Arun District Council
Arun Civic Centre
Maltravers Road
Littlehampton
West Sussex BN17 5LF
Planning & Building Control General Enquiries
Tel: (01903) 737756 Fax: (01903) 730442
Dx: 57406 Littlehampton
Minicom: 01903 732765
e-mail: planning@arun.gov.uk
website: www.arun.gov.uk/planning

Application No: AB/116/20/HH
Site Address: 42 Fitzalan Road Arundel BN18 9JS
Description of works: Single storey rear extension to replace conservatory

Proposed Ground Floor Plan

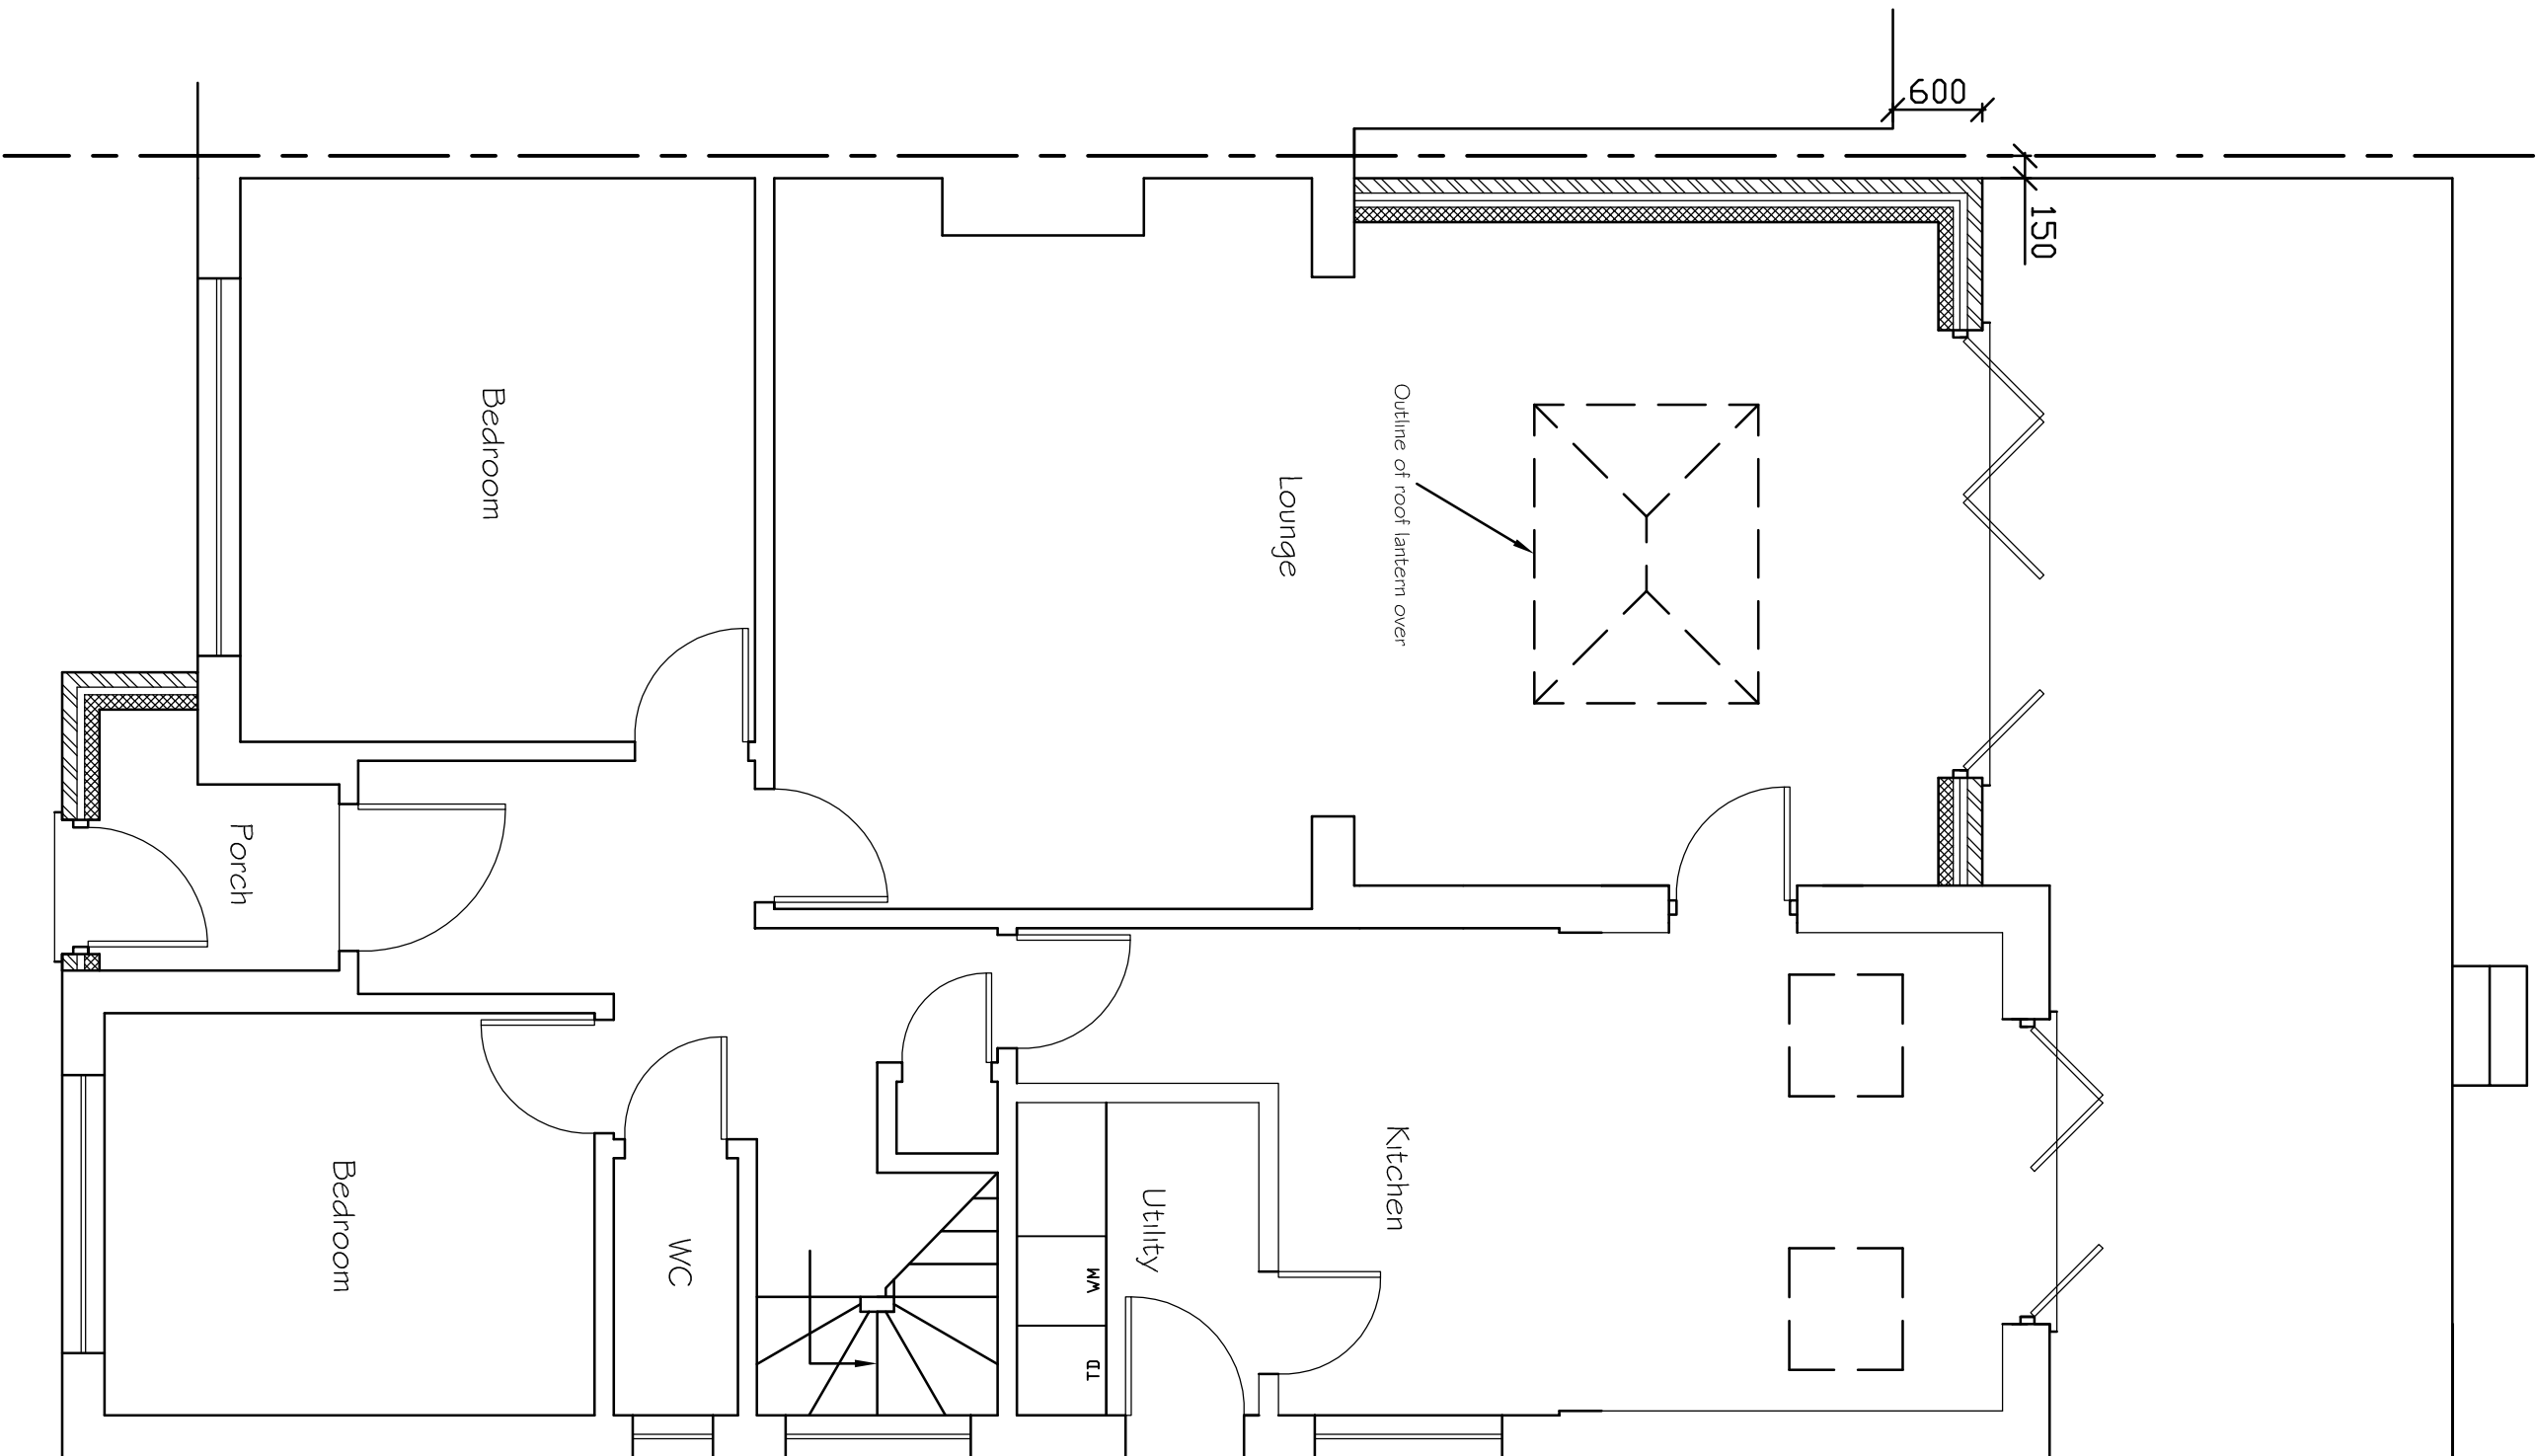
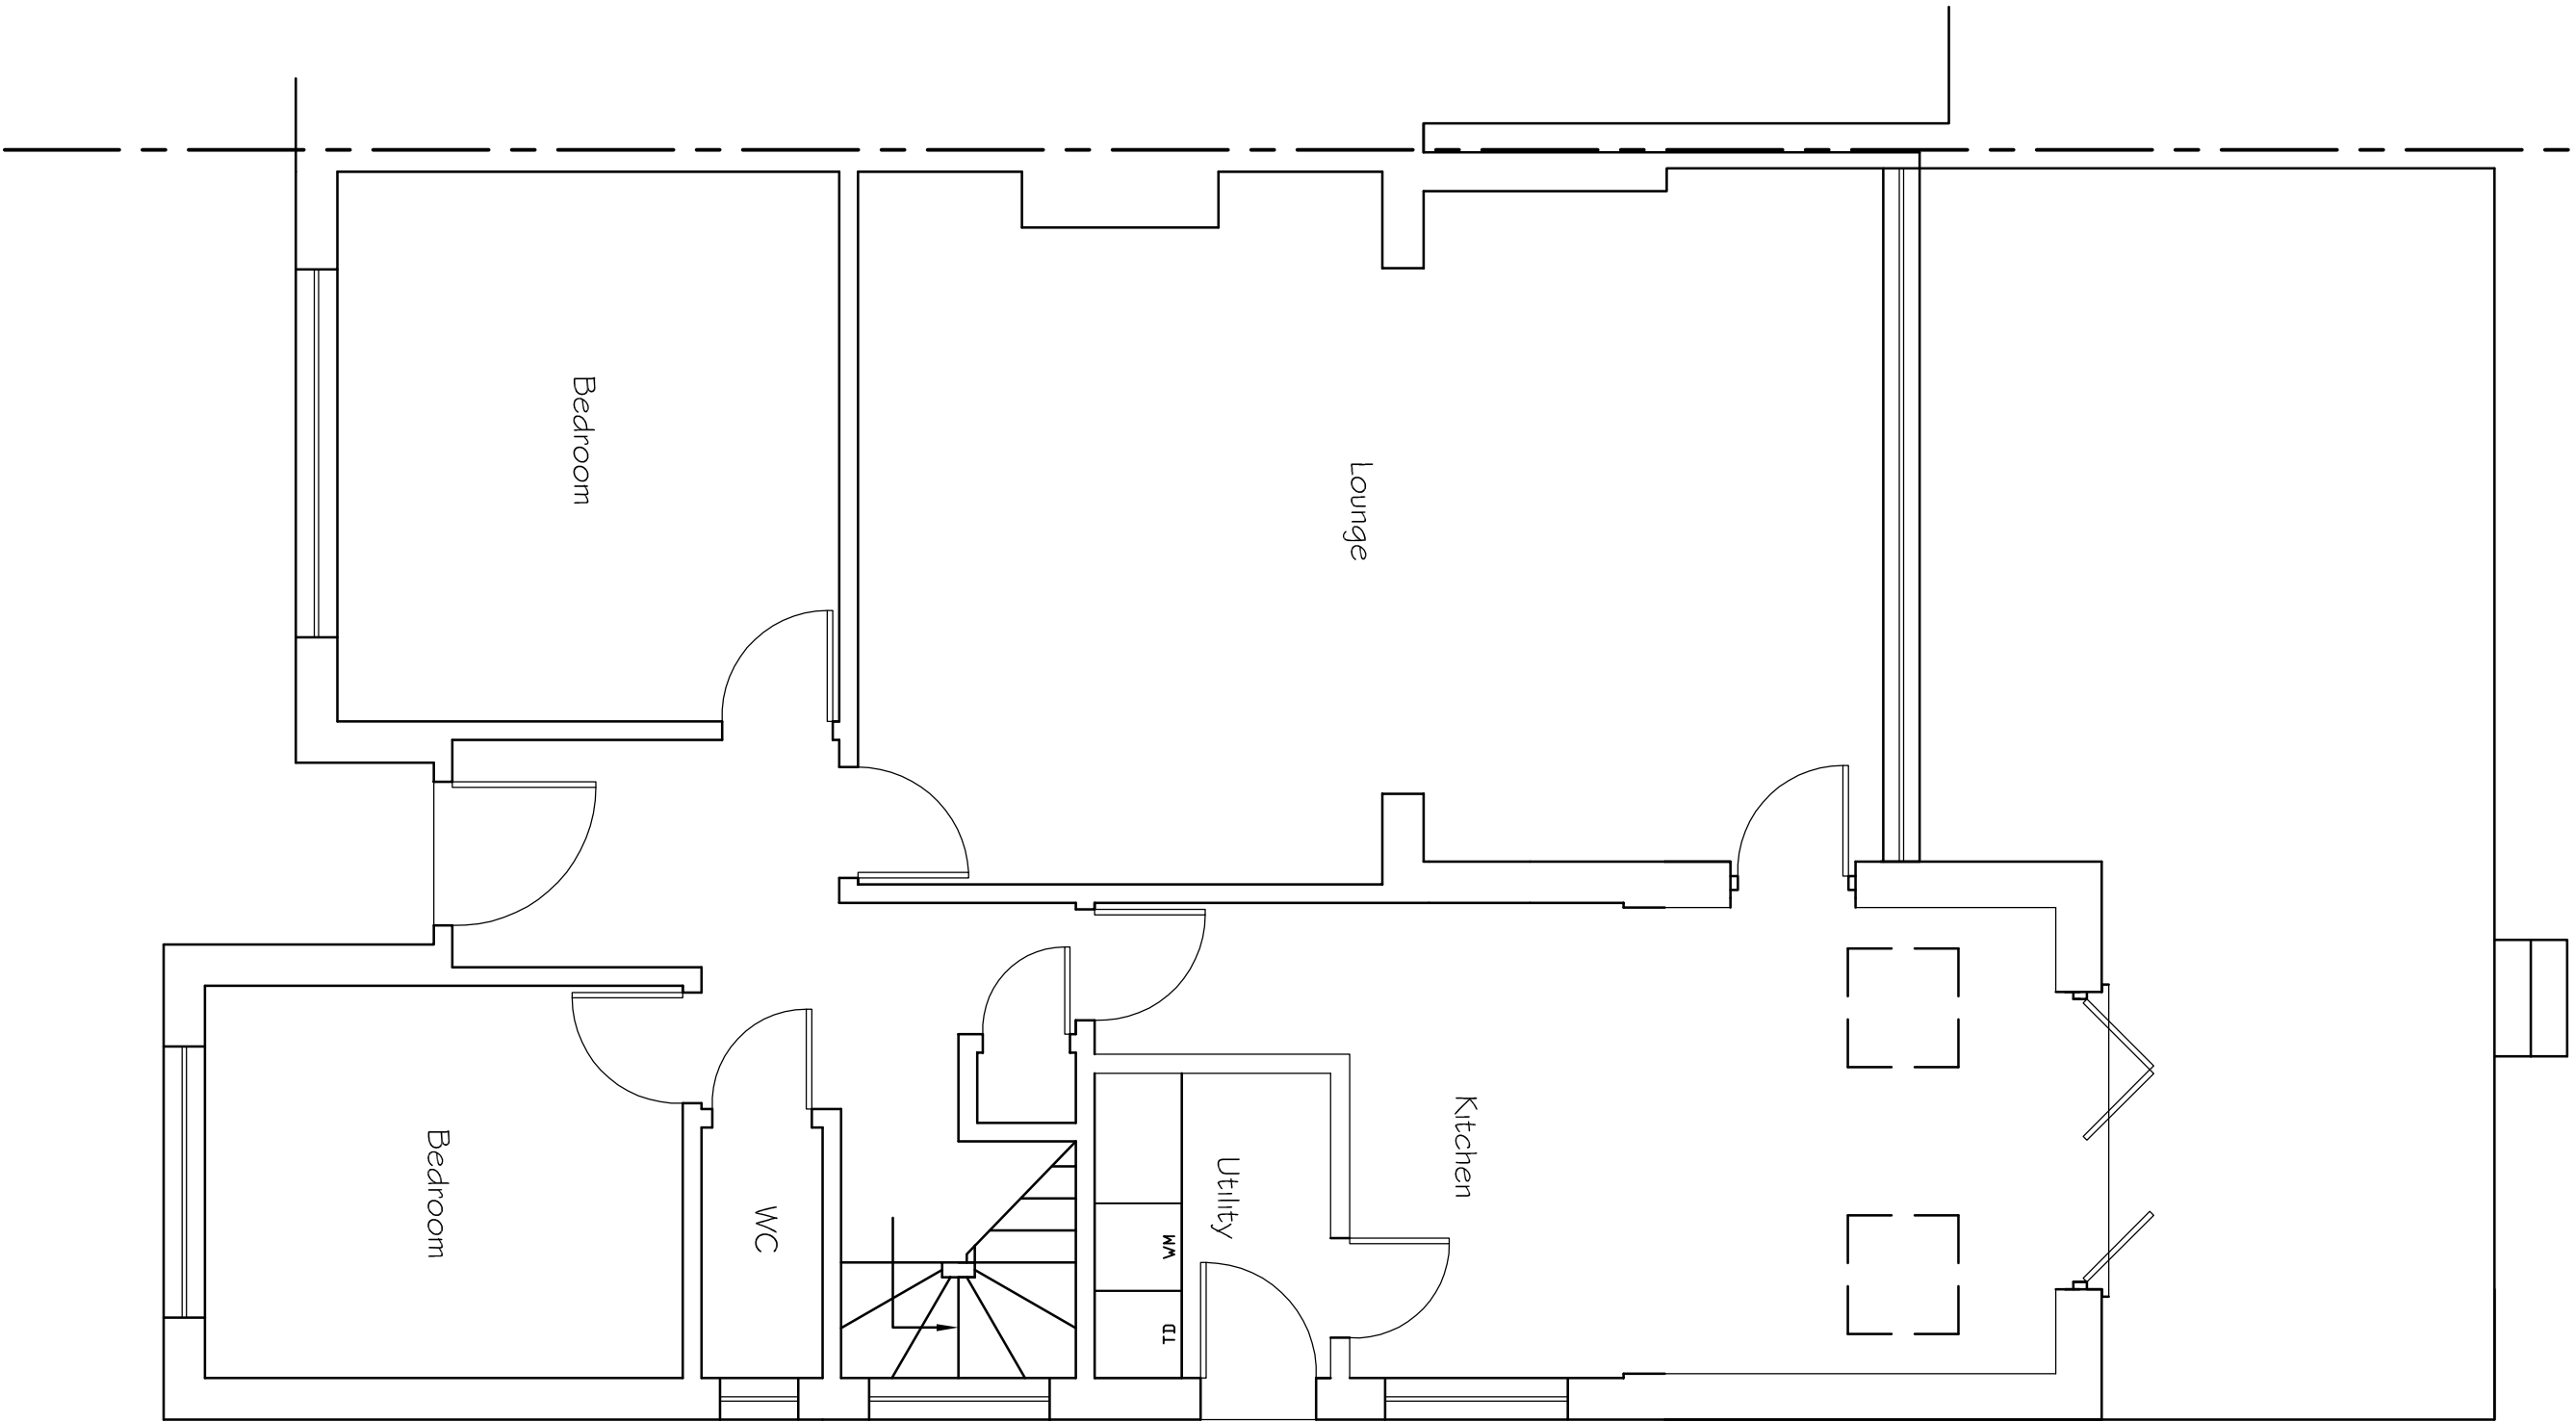
I live at 44 Fitzalan Road, the adjoining property. My comments are as follows: 1) Please confirm that the measurement of 150mm on the plan describes the distance from the Western wall of the proposed structure to the property boundary. 2) Fences and plants on the boundary of 44 Fitzalan Road should be treated with care and respect. The garden at No. 44 has been maintained organically for 23 years and is a haven for bees and other pollinators. 3) [REDACTED] Covid 19 restrictions are still in place, there will be a requirement for all persons working within 2 metres of our property to wear face coverings. Would Mr Stringer, as applicant and agent, confirm that he will be responsible for ensuring that this requirement is observed.
